MEMORANDUM

Subject: Application ID: 2017-289

Date: 1/18/2018

[ East Towers ] Logistics Plans and Studies

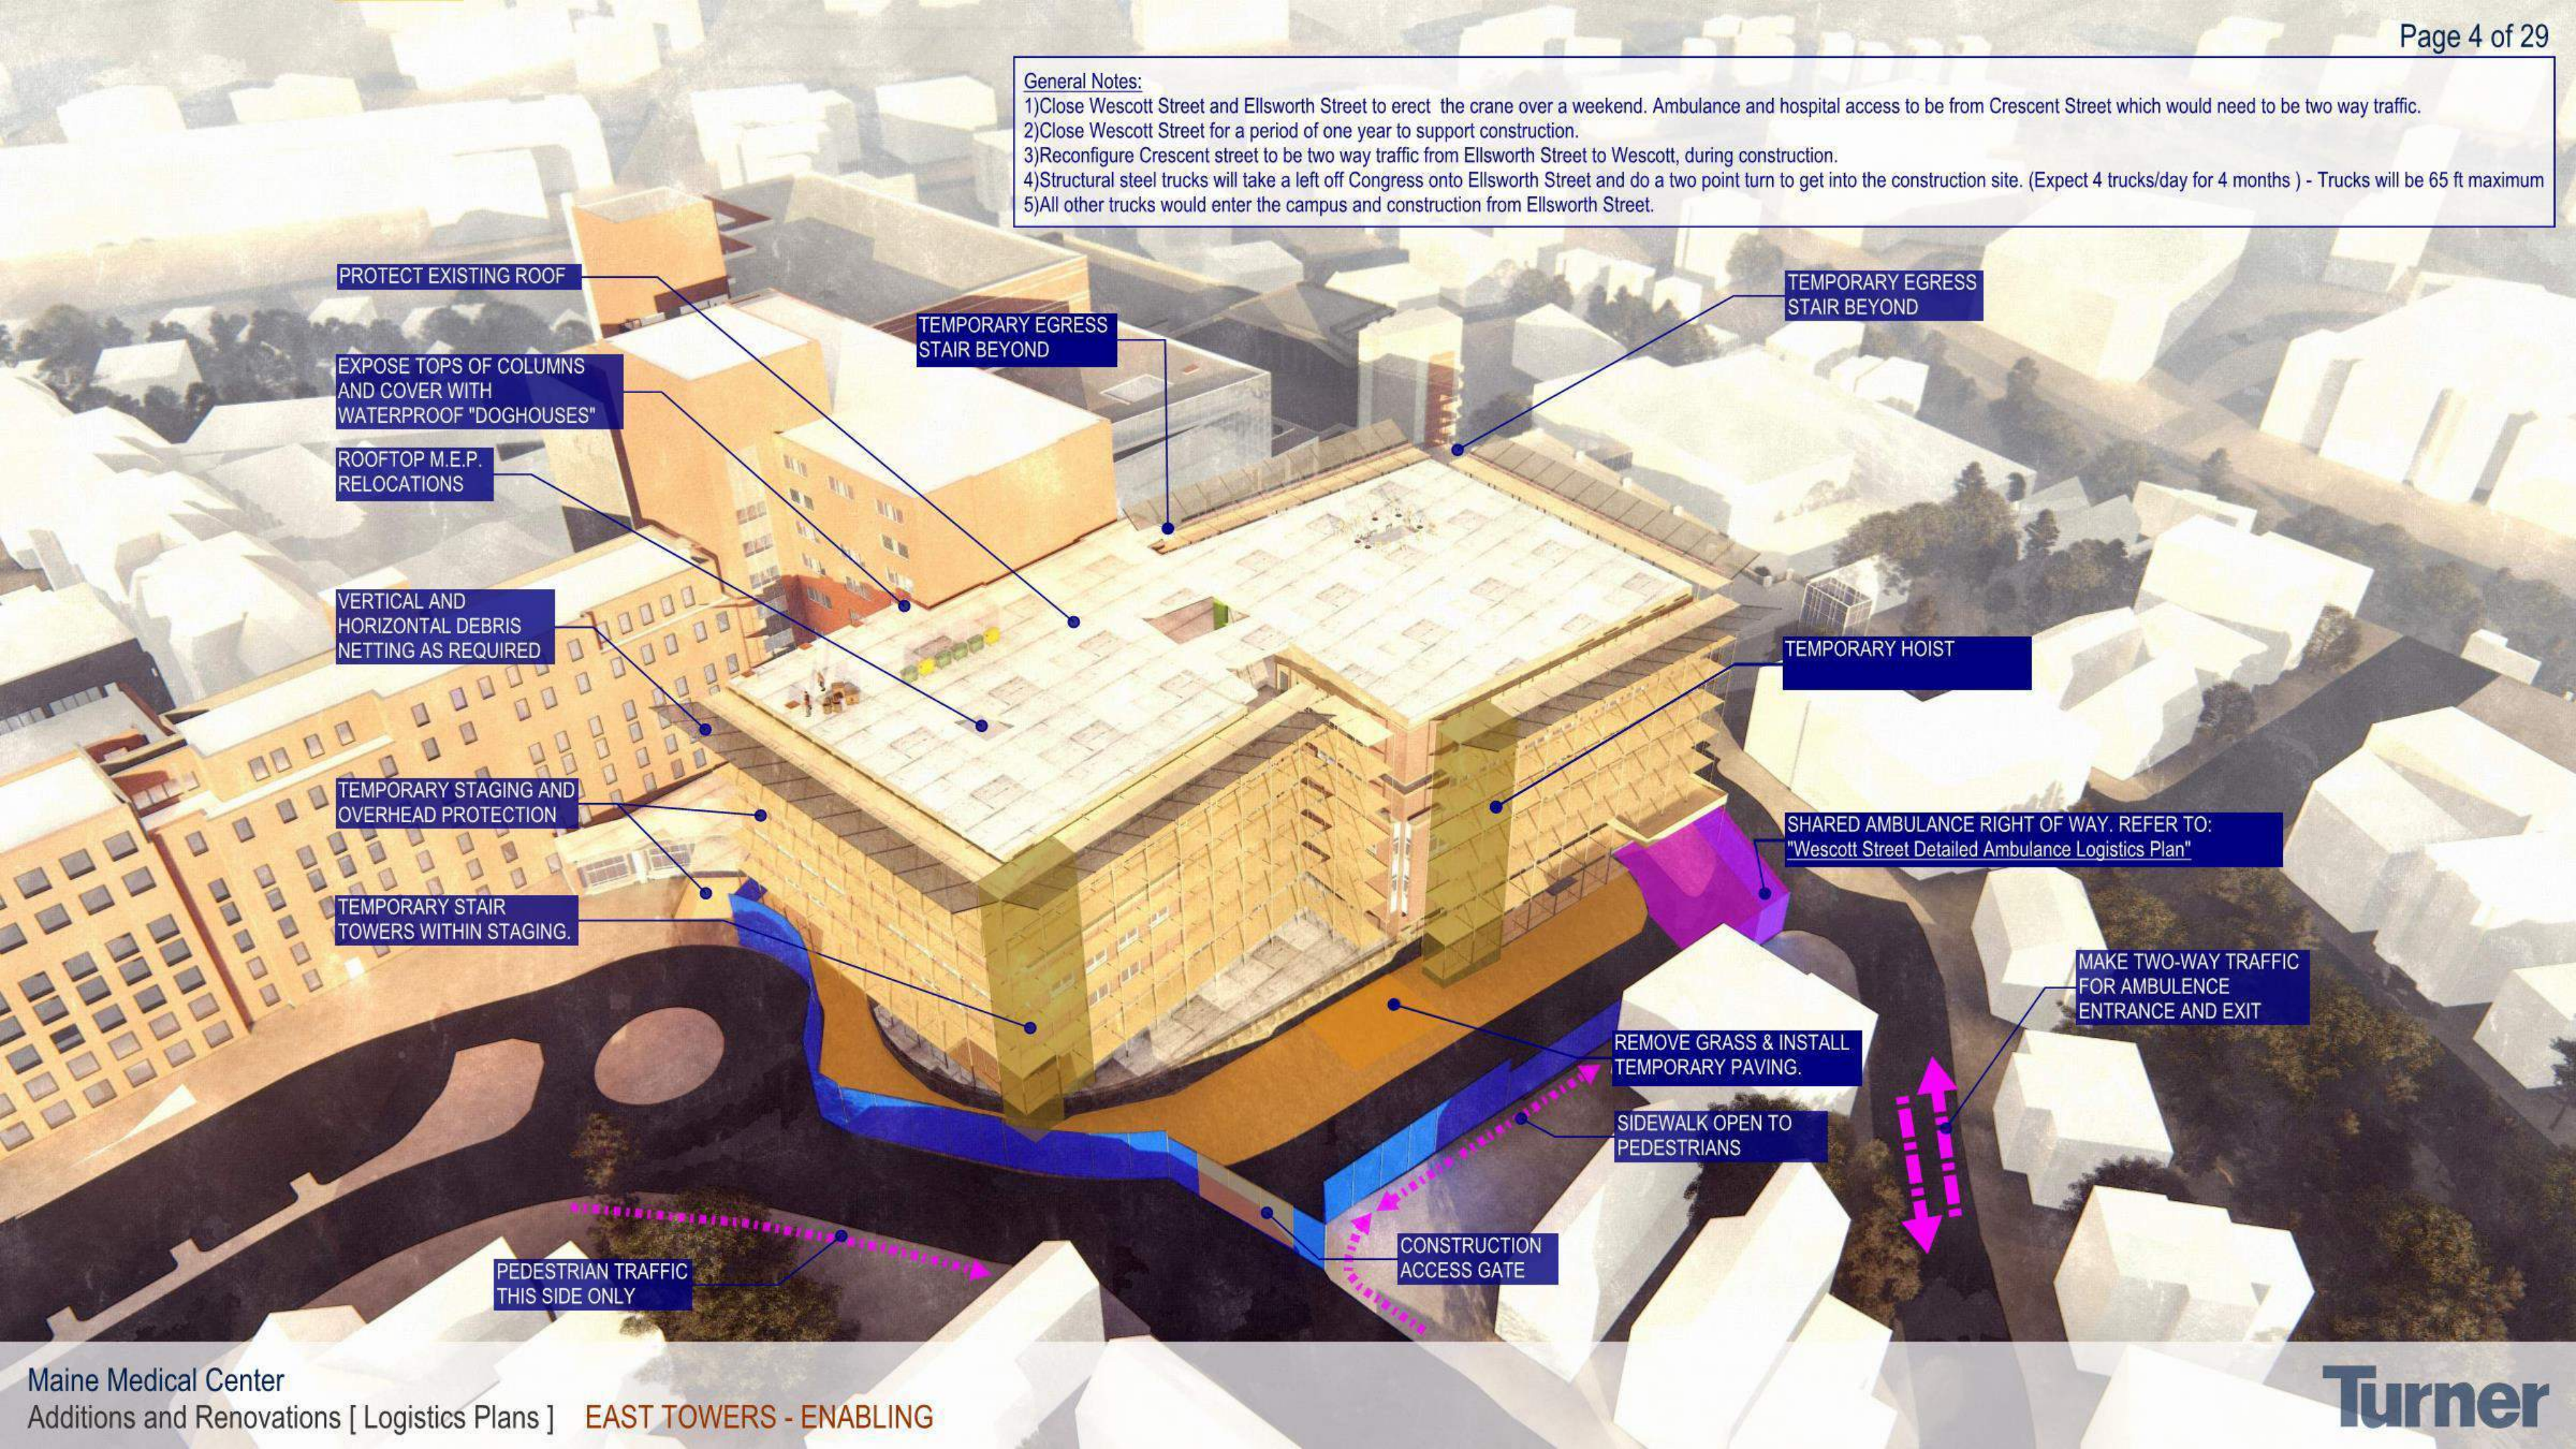
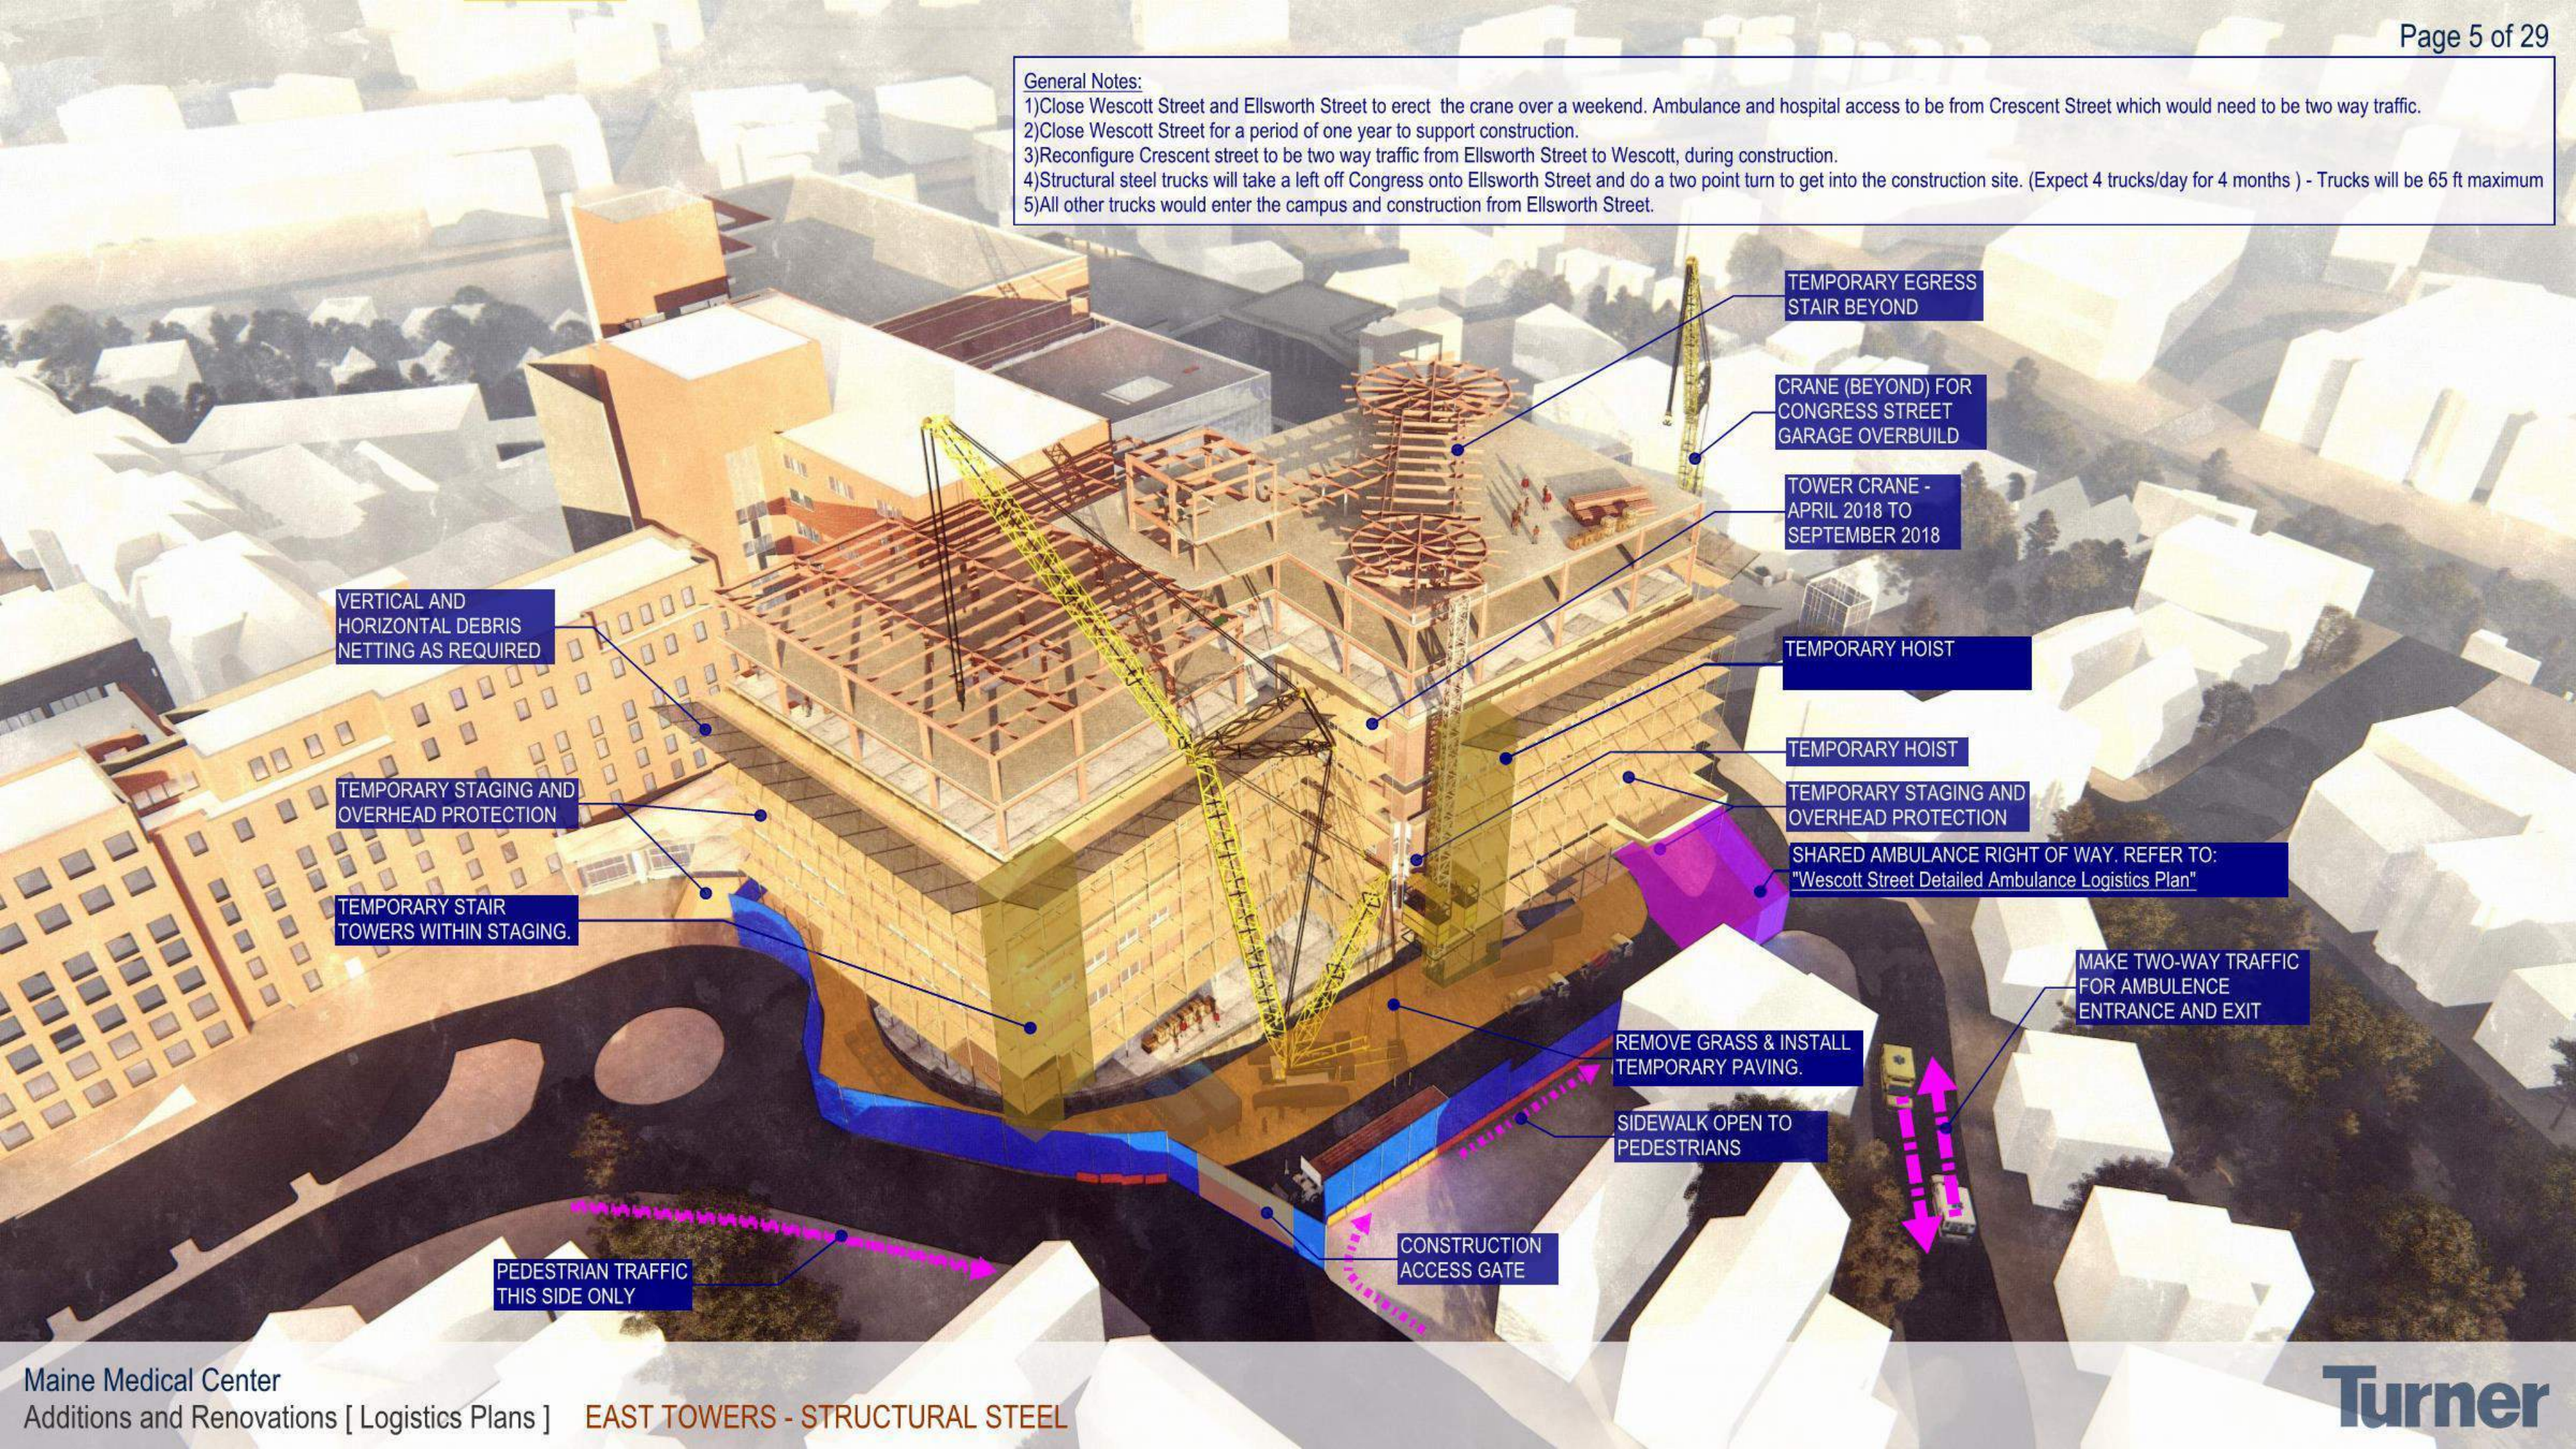
Circulation--The ambulance emergency room entrance should remain open to one way traffic. The area can be difficult to maneuver in its current design. Making the patient delivery area a two way drop off doesn't seem achievable.
